Access Report

**New Stables Complex**  
**Newcastle Jockey Club**  
Cnr Chatham & Darlings Streets  
BROADMEADOW NSW

For: Newcastle Jockey Club  
Ref: LP\_21369

OVERALL GROUND FLOOR PLAN

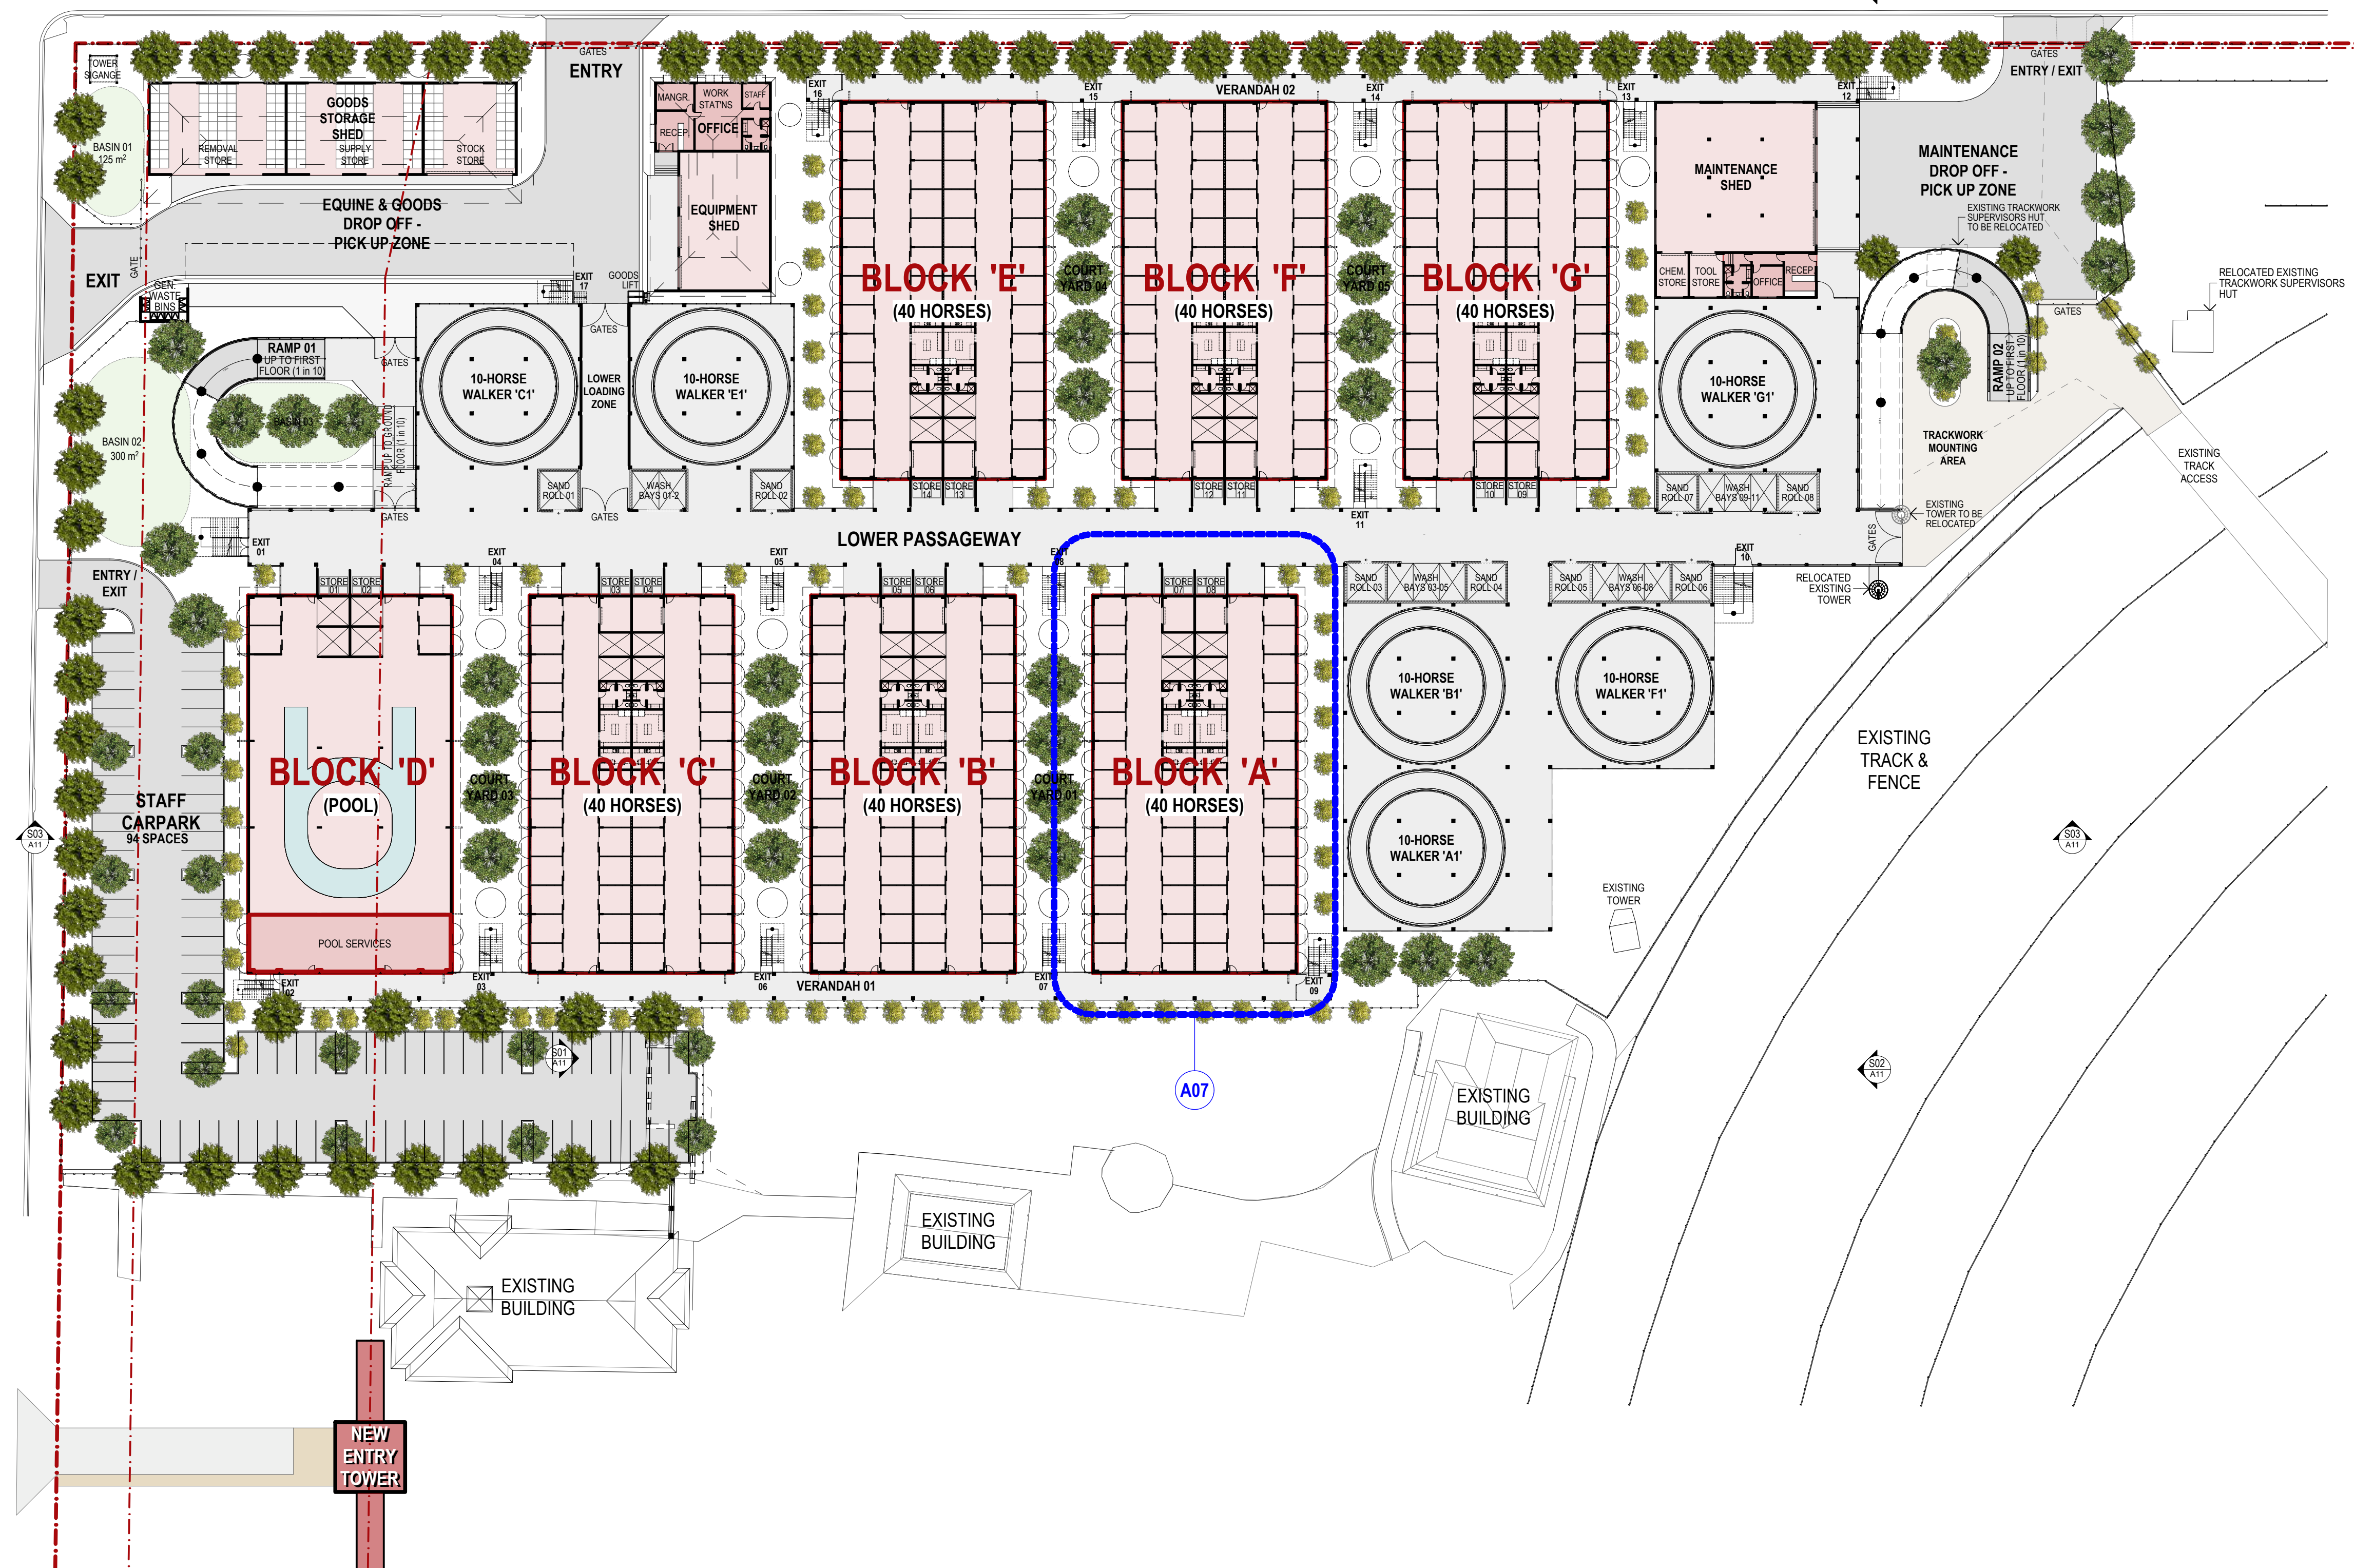
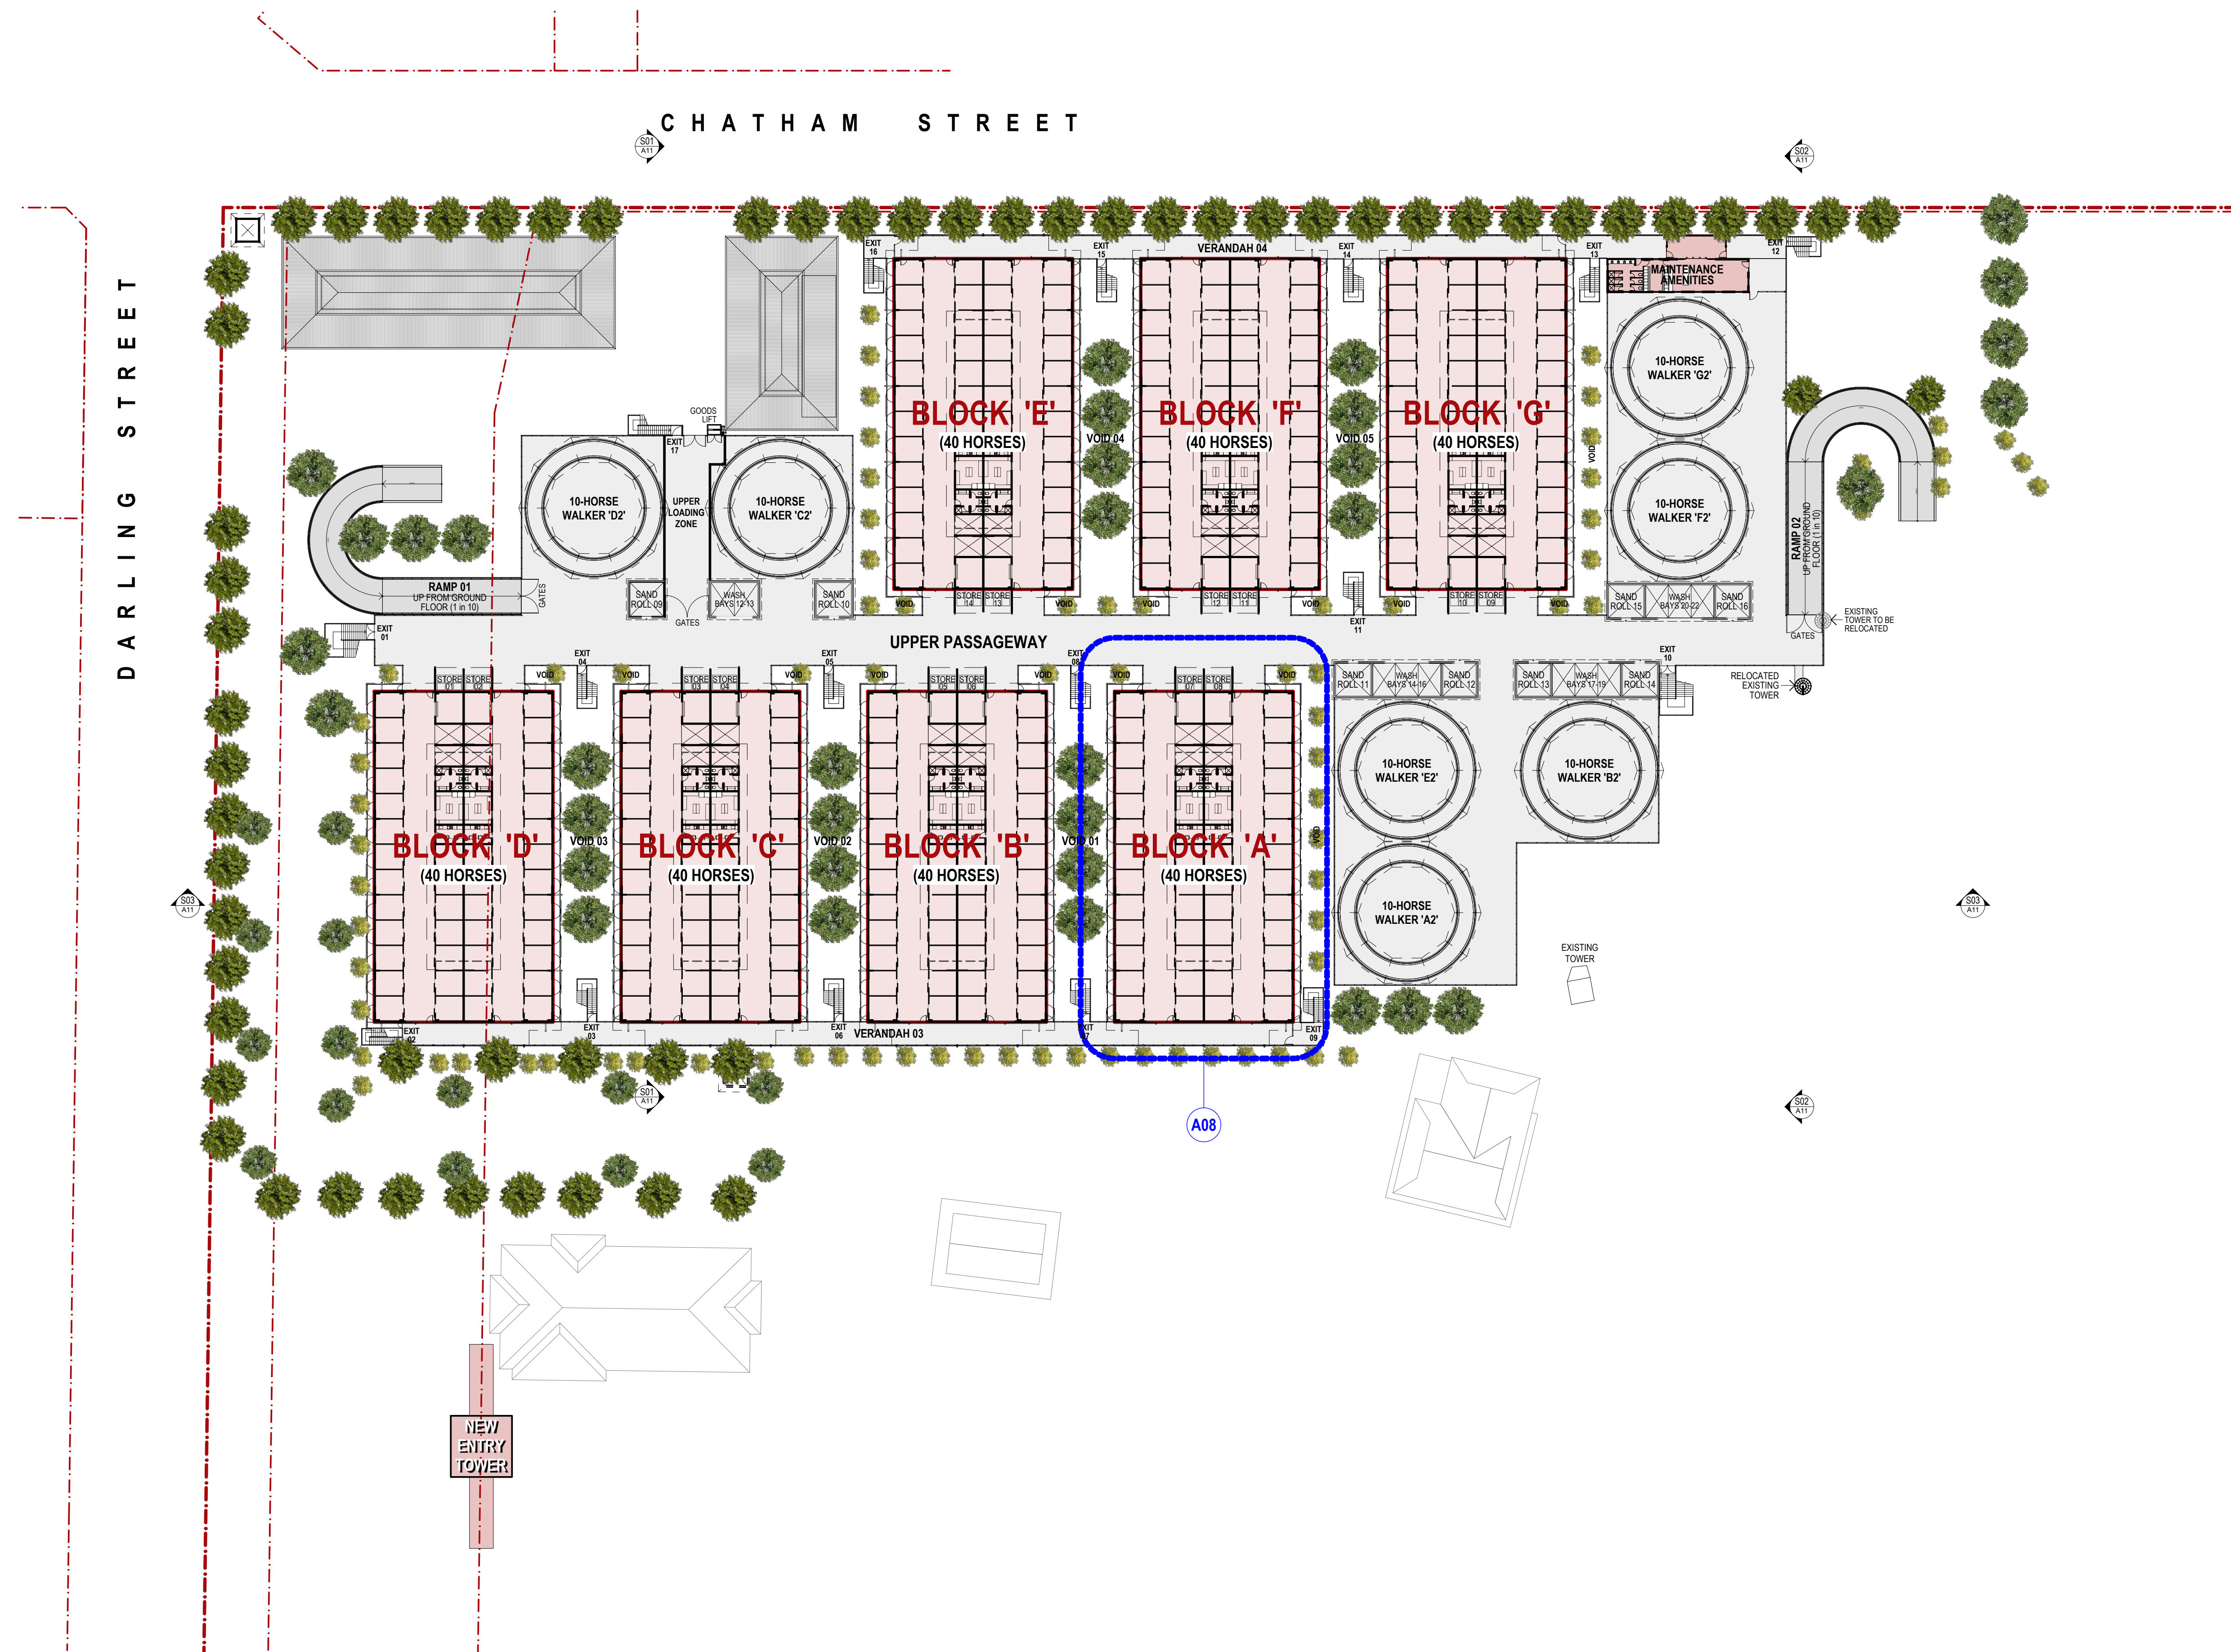
The location of accessible carparking areas is not indicated in the site plan. However, the path of travel from the car parking areas and the Office Building is conducive to an accessible path of travel.

The location of accessible car parking is not indicated on the site plan. Carparking areas are generally level and conducive to the provision of designated accessible car parking.

- a. Accessible carparking to be a minimum of 2400mm wide with a shared area to one side of the space 2400mm wide. Circulation space can be shared between adjacent accessible carparks.

- b. Provide a bollard to the shared circulation space as illustrated in AS2890.6, Figure 2.2.
- c. The maximum allowable crossfall of accessible carparking area to be, 1:40 (1:33 for bituminous surfaces). This crossfall applies both parallel and perpendicular to the angle of parking.

- d. For covered carparking, the clear height of the accessible carparking space to be 2500mm as illustrated in AS2890.6, Figure 2.7.
- e. Designated accessible carparking is to be identified using the International Symbol for Access (ISA) between 800 and 1000mm high placed as a pavement marking in the centre of the space between 500-600mm from its entry point. The perimeter of the space is to be identified by an unbroken yellow & slip resistant line 80-100mm wide (except where there is a kerb or wall)
